Re. Chain Valley Colliery - Modification 4 (SSD-5465-Mod-4)

I refer to your request of 23 November 2020 for advice regarding Chain Valley Colliery Modification 4. The Resources Regulator has reviewed the request.

Figure 4 | Chain Valley Colliery's proposed revised subsidence management zones

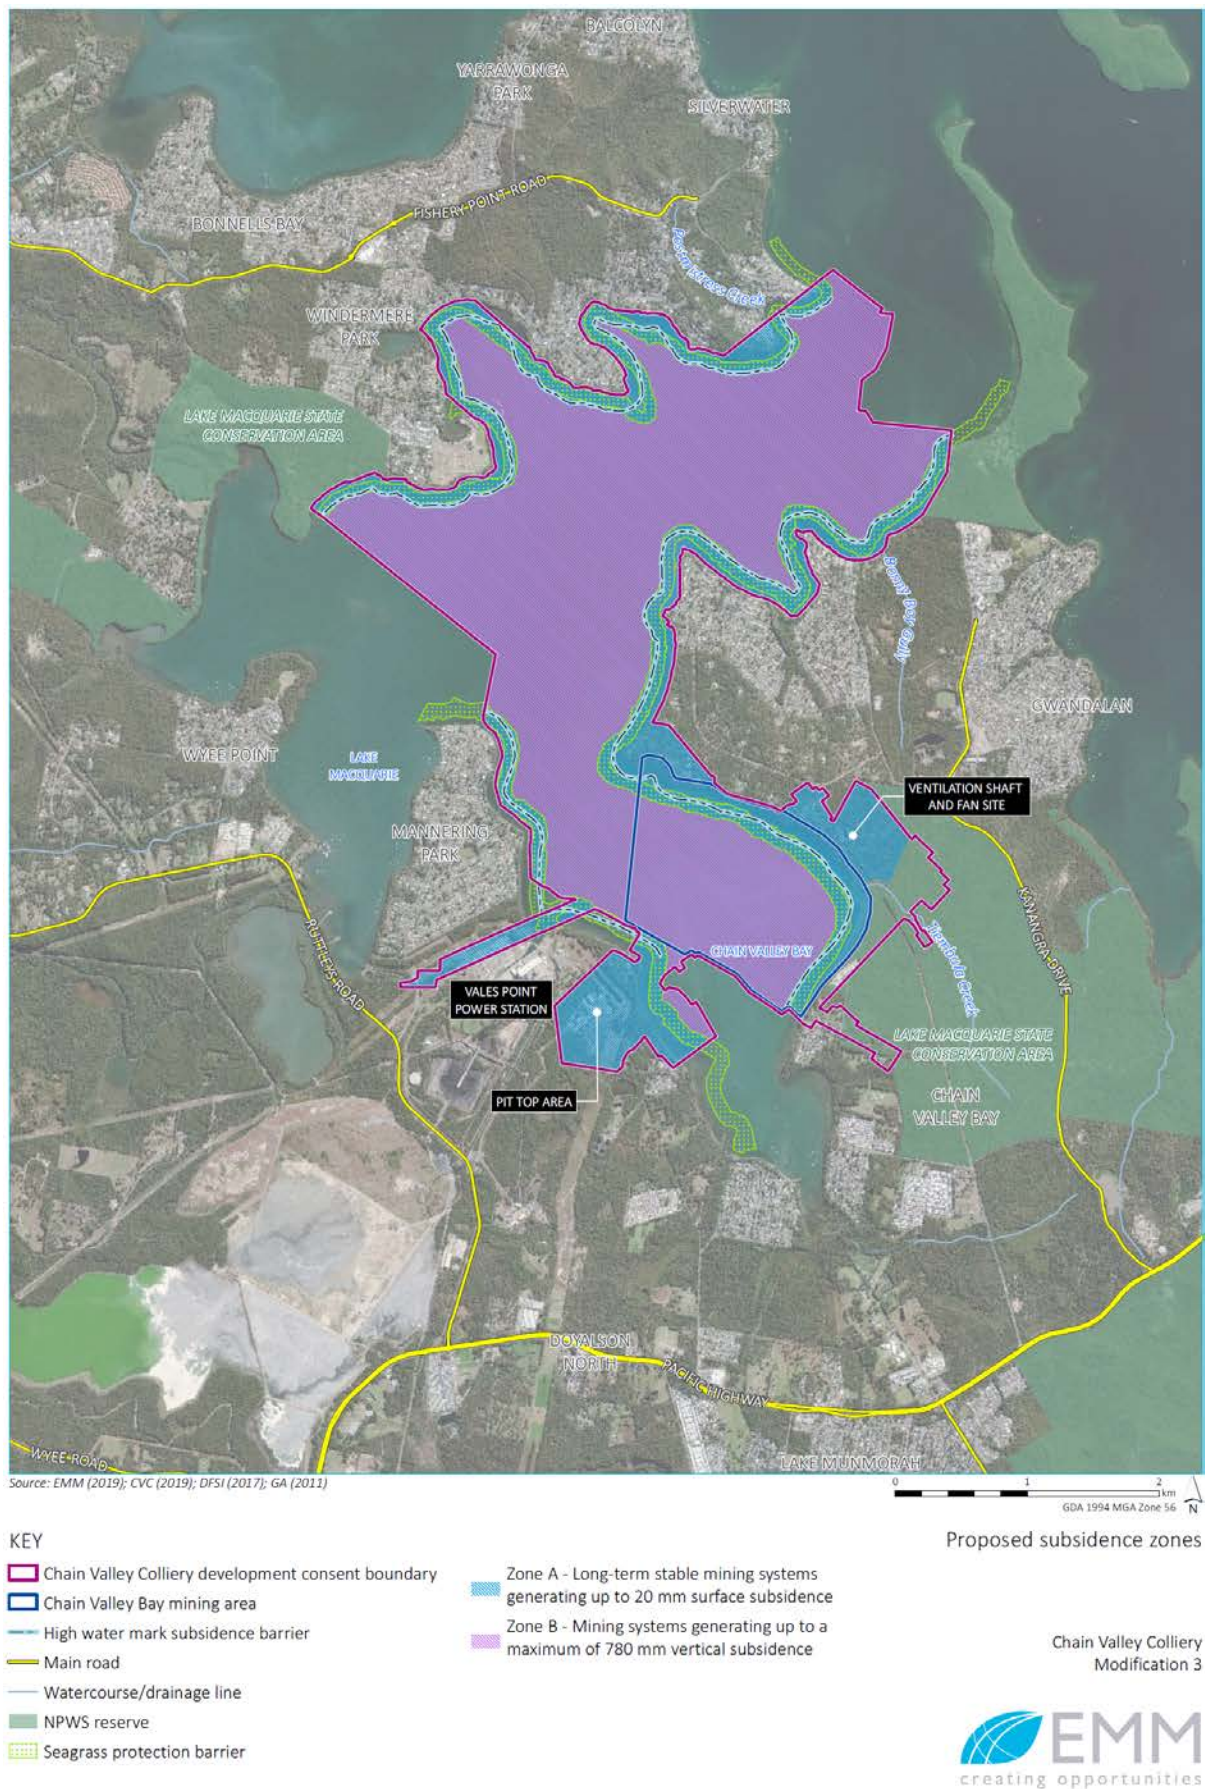
In regard to subsidence, the Resources Regulator has identified issues around the proposed management of this hazard. The proposal to mine using the first workings method in the Northern Mining Area (NMA) and a suggested subsidence limit of 20mm poses several issues that require additional consideration. The Regulator notes that the NMA underlies the Lake Macquarie foreshore, residences, roads, infrastructure and other amenities.

The geotechnical assessment indicates the proposed workings' floor has the potential to be comprised of soft claystone. No other site-specific information relating to seam floor conditions has been presented in the geotechnical assessment.

Soft claystone in the roof or floor strata is known to have the potential to adversely affect the performance of coal pillars, in terms of both overall stability and/or increased subsidence due to excessive settlement. It is not clear that the geotechnical assessment has taken into consideration the effects of the potential soft floor materials.

The Regulator also notes that in 2017 measured subsidence over mini-walls MW7 to MW12 at Chain Valley Colliery substantially exceeded predictions. The mine operator's geotechnical consultant at the time concluded this was due to yielding (i.e. failure) of the claystone floor causing "pillar-punching" of the mini-wall chain pillars.

Despite the differences in layout and pillar loading conditions of the mini-walls, this previous subsidence incident highlights the potential adverse effects on pillar performance in the NMA due to possible soft seam floor conditions.

In the absence of site-specific information or assessment relating to the potential effects of soft seam floor conditions in the NMA and given the proposed mine layout it is possible the predicted subsidence limit of 20 mm will be exceeded.

- Require the proponent to undertake investigations into the site-specific conditions, specifically the Fassifern Seam floor in the NMA;

- Commission an independent review into the mine layout design taking into consideration the results of the abovementioned site-specific investigations and the previous exceedance of subsidence predictions for mini-walls MW7 to MW12.
